Application No: EP/167/21/HH

Site Address: 2 Vicarage Lane East Preston BN16 2SP

Description of works: Erection of single storey rear and side extensions with mono pitched roofs and installation of fencing to front and side.

Thank you for your internet representation made on 31st January 2022 which has been recorded as an objection with the comments as follows:

GA 007

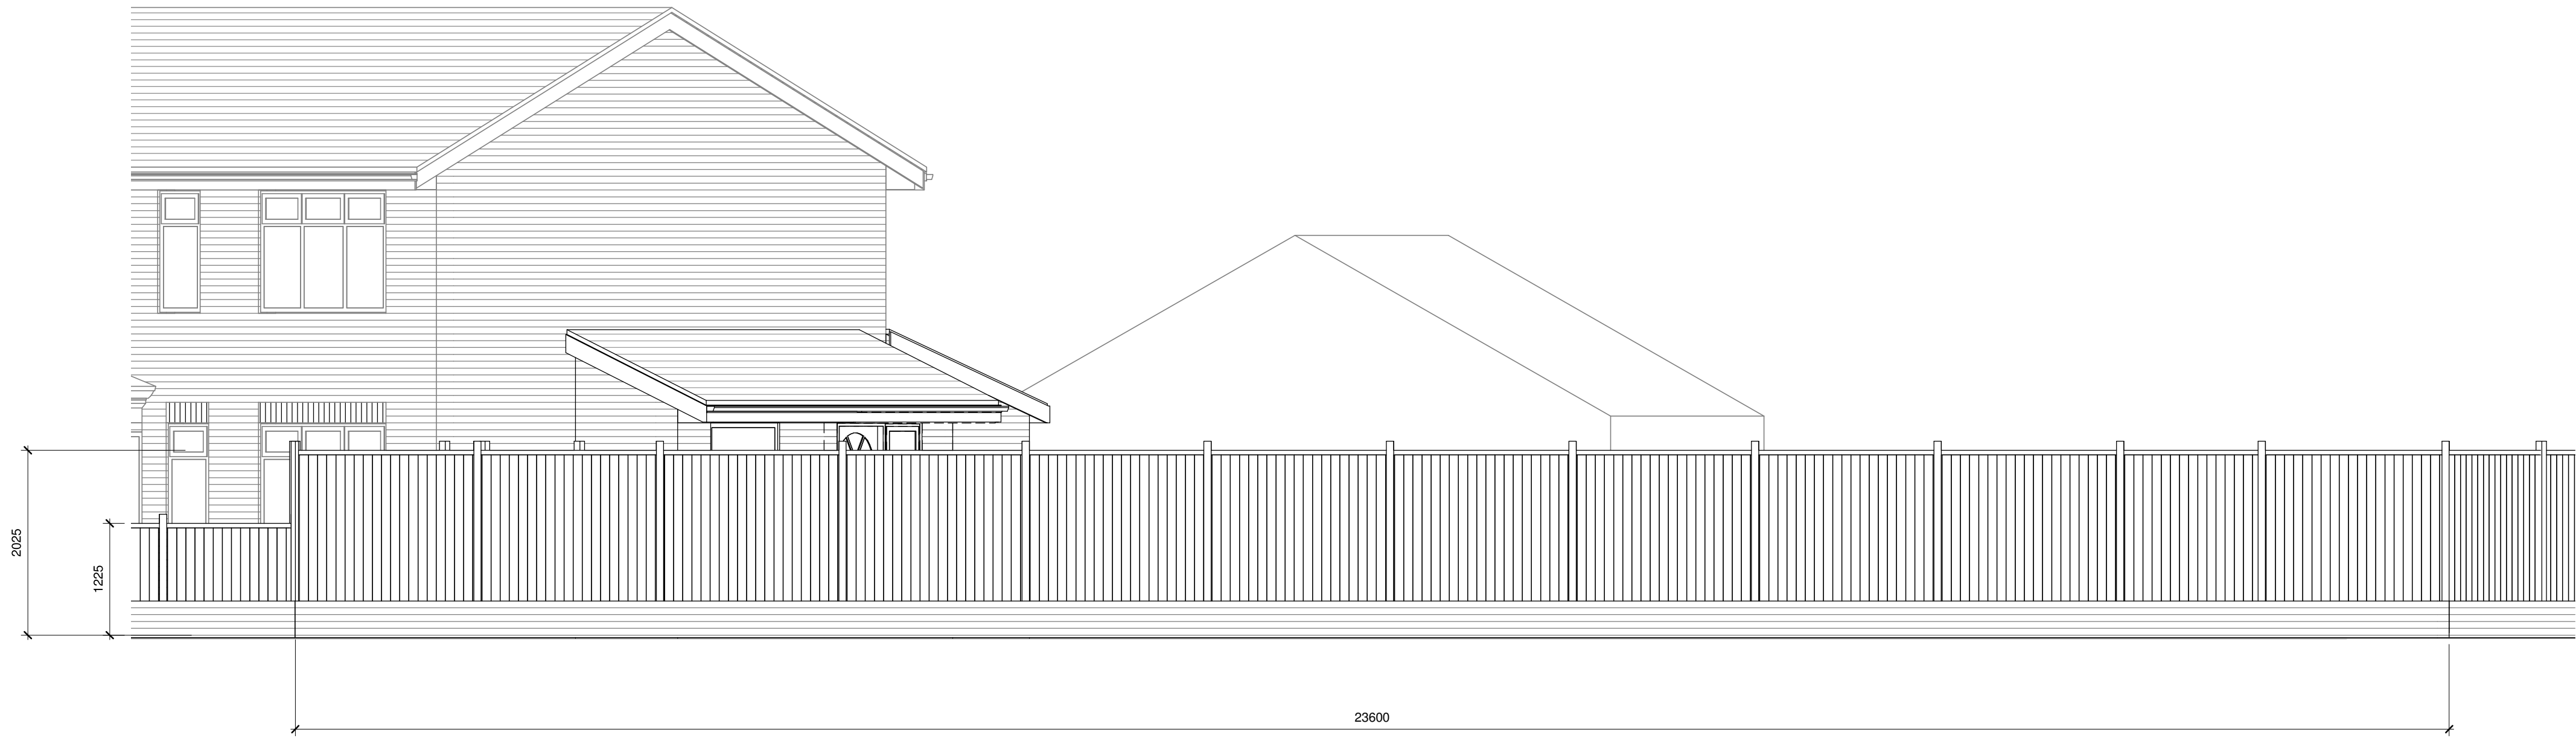
I feel that the main fencing is 2 metres tall which is completely out of character for this section of the pavement & verge and would think it will look out of place and awful. We understand that they want privacy, though the two owners before them spent over 50 years without any concerns, and we would have thought a natural hedge would be more appropriate.
